## Appeal Decision

**Appeal Ref: APP/R4408/W/20/3253900**

**Woodstock Road, Barnsley S75 1DX**

- The appeal is made under section 78 of the Town and Country Planning Act 1990 as amended against a refusal to grant outline planning permission.
  - The appeal is made by Mr S Clayburn against the decision of Barnsley Metropolitan Borough Council.
  - The application Ref: 2019/1262, dated 9 October 2019, was refused by notice dated 21 April 2020.
  - The development proposed is demolition of 49 Woodstock Road and residential development of 3 no. dwellings (Outline with all matters reserved apart from means of access).
-

TITLE
VEHICLE TRACKING & ACCESS

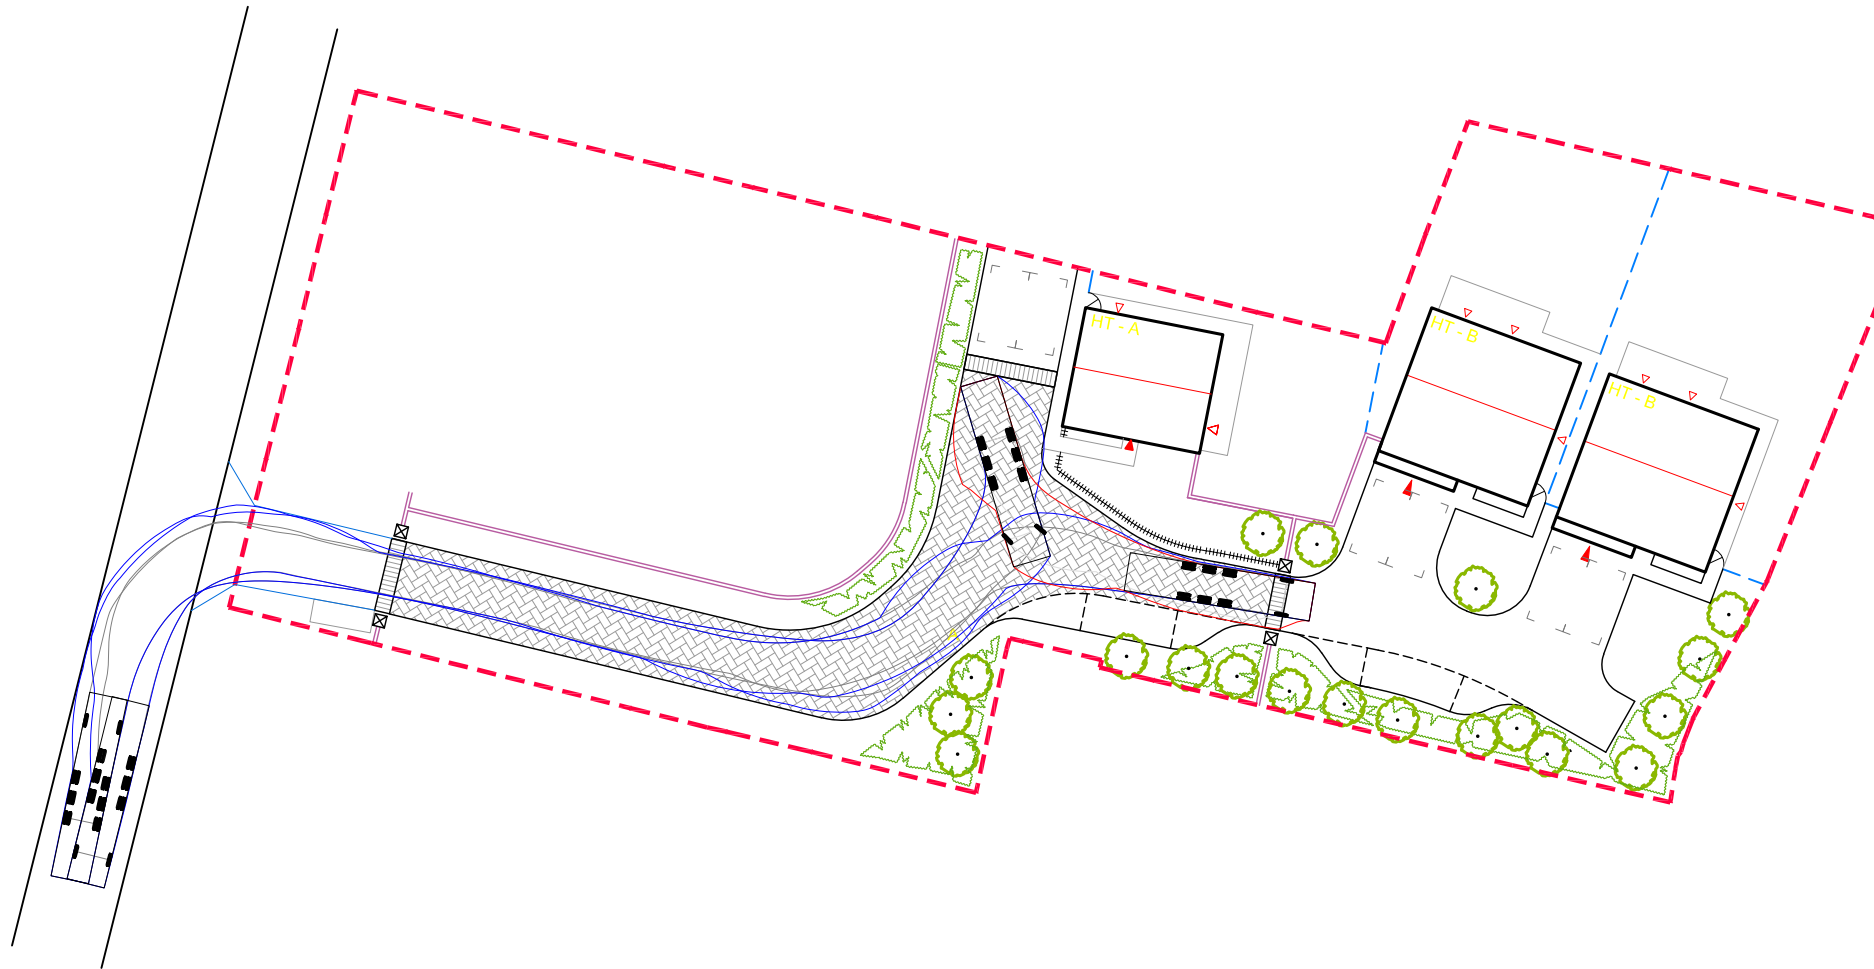
9. The swept path analysis indicates that the proposed development would accommodate a turning head large enough for service vehicles including a refuse lorry to access the proposed cul-de-sac. However, the Council's highways team advises that the authority would not adopt a development of five houses or less, and therefore refuse collection would not be carried from within the development but from a refuse collection area close to the adjoining public highway. Judging by the indicative site layout, the proposed houses would have a 'man carry distance' (MCD) for future occupants' bins to street collection point of around twice or more than the 30m maximum that is recommended in the Barnsley Design of Housing Development Supplementary Planning Document (2019) (HSPD).

10. Therefore, it is not shown that the refuse collection service would in practice manoeuvre a large bin lorry in and out of the proposed three dwelling cul-de-sac. Consequently, there would not be a demonstrably practical and realistic refuse collection arrangement for the proposed development.

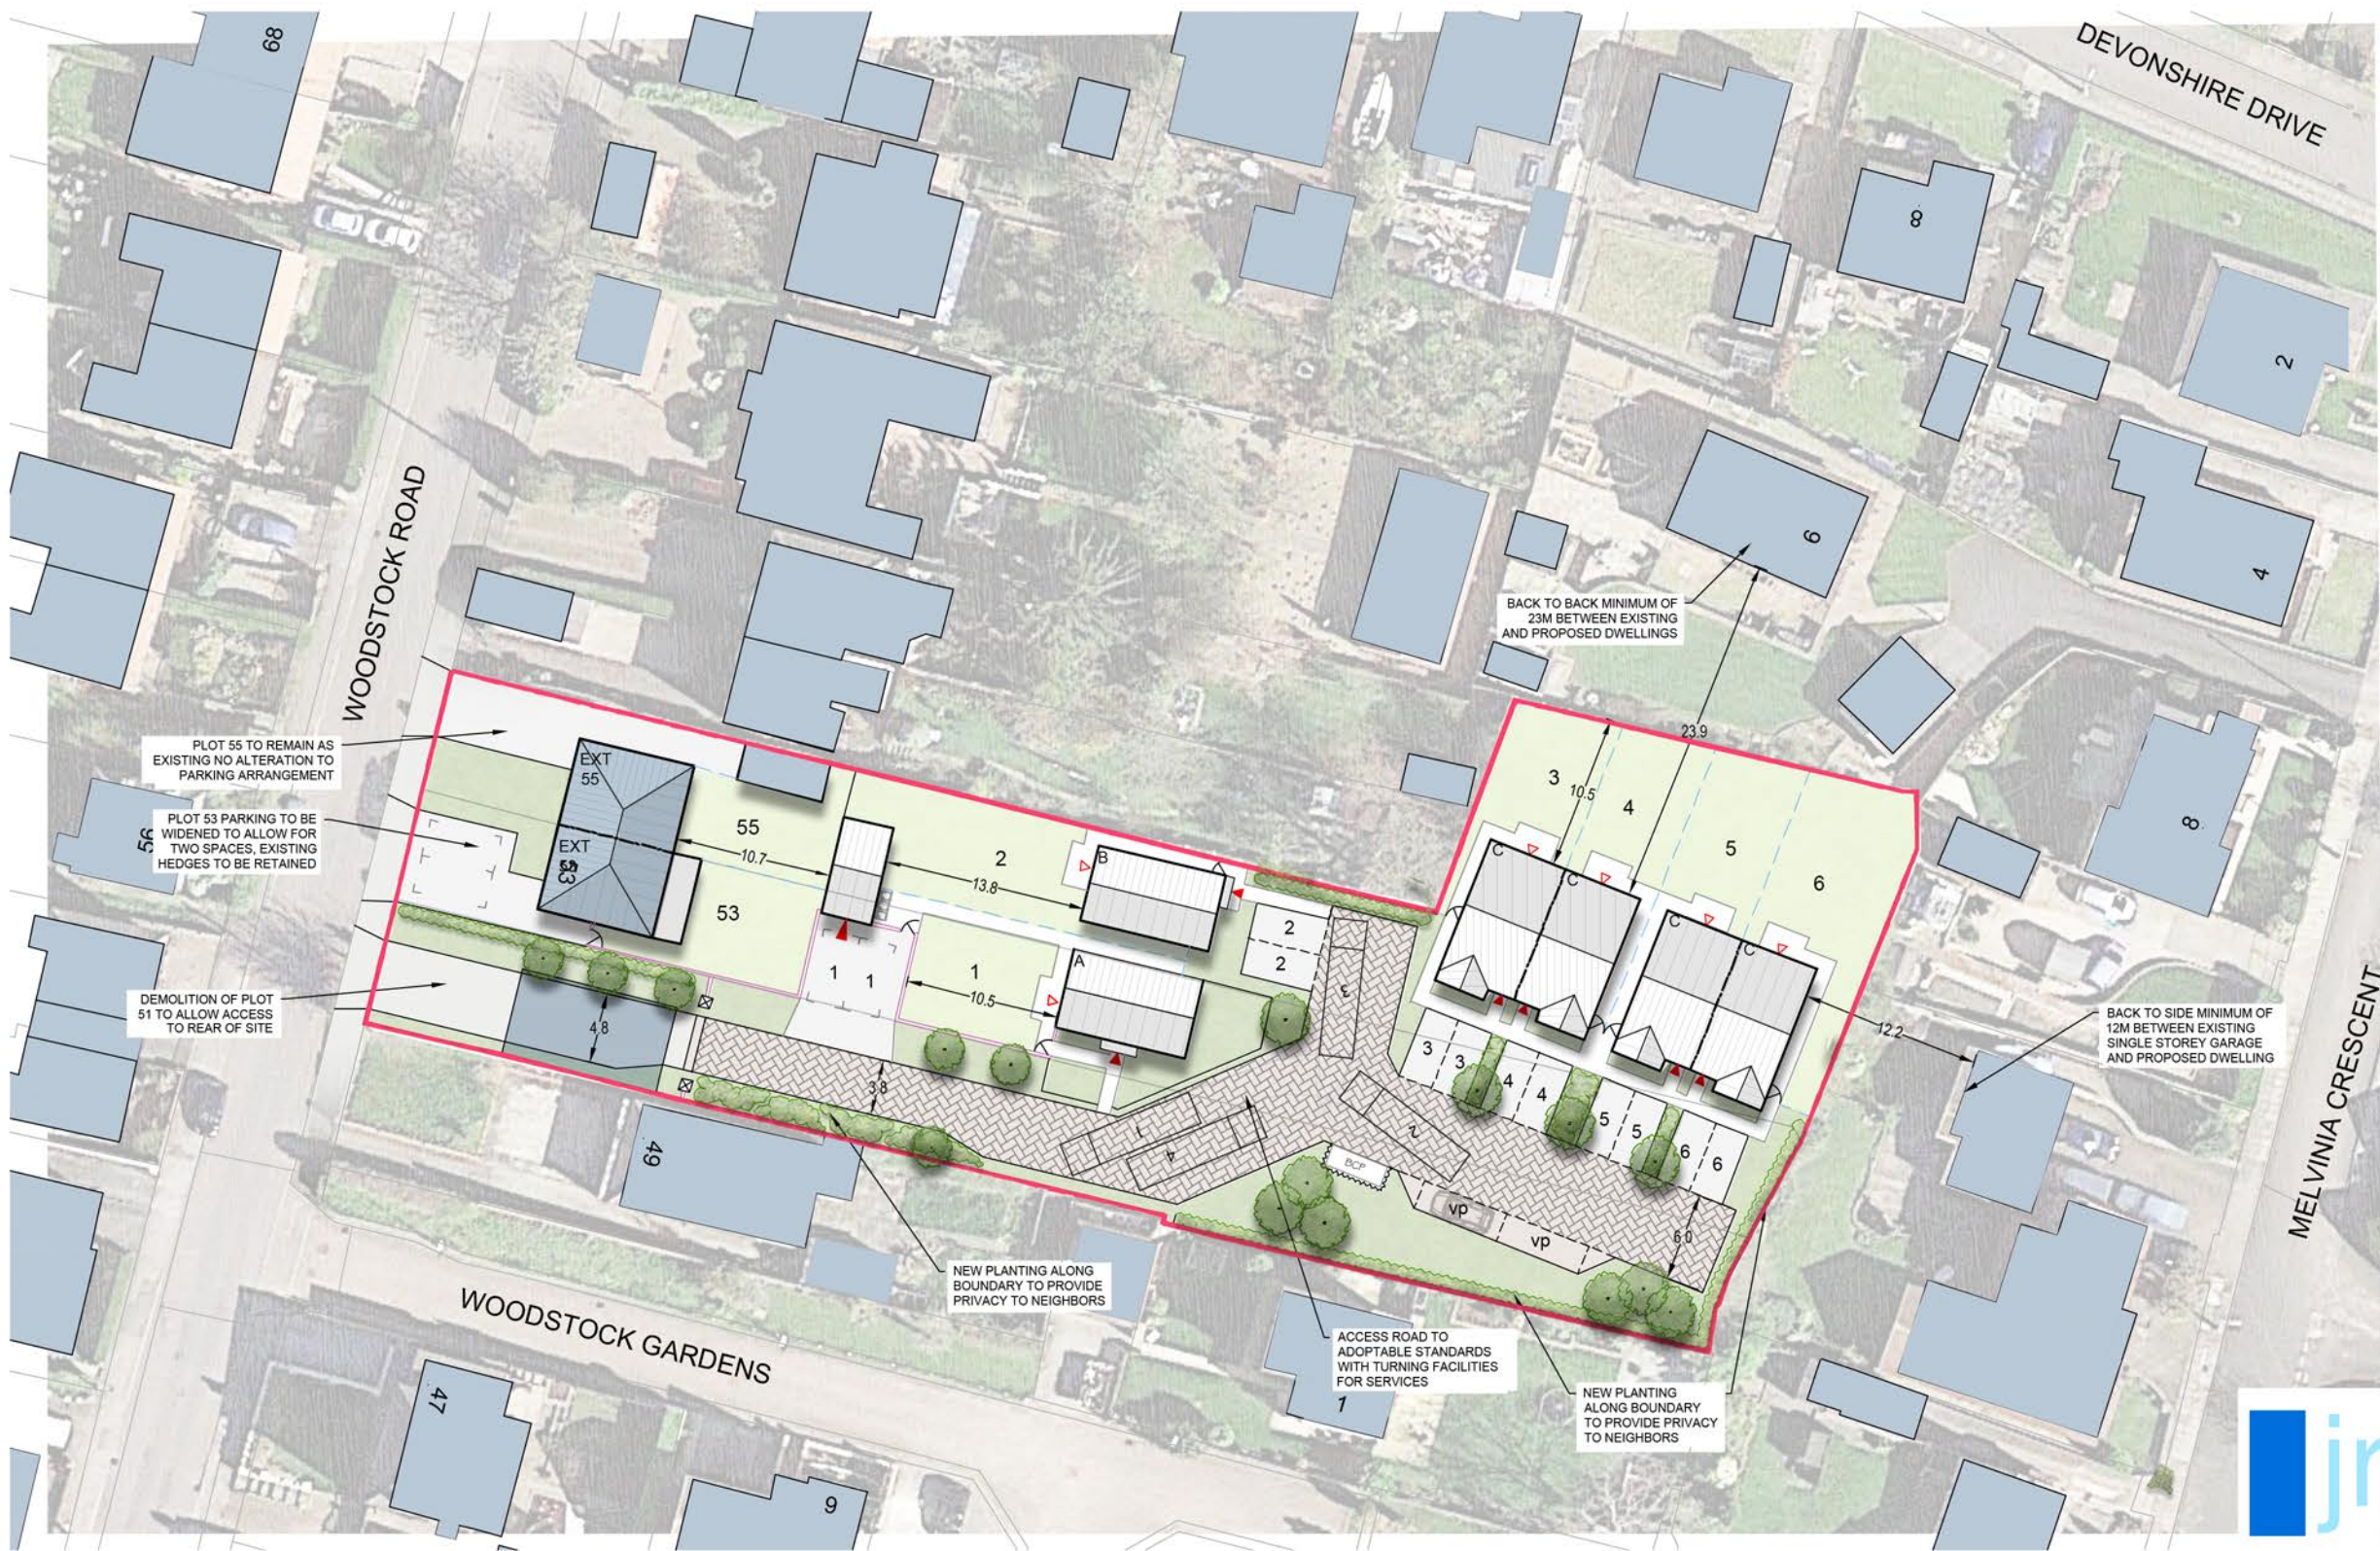
17. The proposal would result in reduction of rear gardens behind a row of four dwellings, with associated reduction in verdancy and spaciousness due to new houses and hard surfacing. The dwellings would also not front onto Woodstock Road and would locate two cul-de-sac entrances close together, separated by a soft landscape strip.

18. That said, the existing rear gardens on the site are particularly long for the neighbourhood and do not appear to be easily maintainable. Furthermore - while the layout, scale and design of the proposed dwellings are not finalised within this outline proposal - judging by the indicative layout it is likely that a) the proposed new dwellings would have sufficiently sized rear gardens, and b) Nos. 51, 53 and 55 Woodstock Road would retain substantial areas of garden space, around 10m deep at the front and more than 20m deep to the rear.
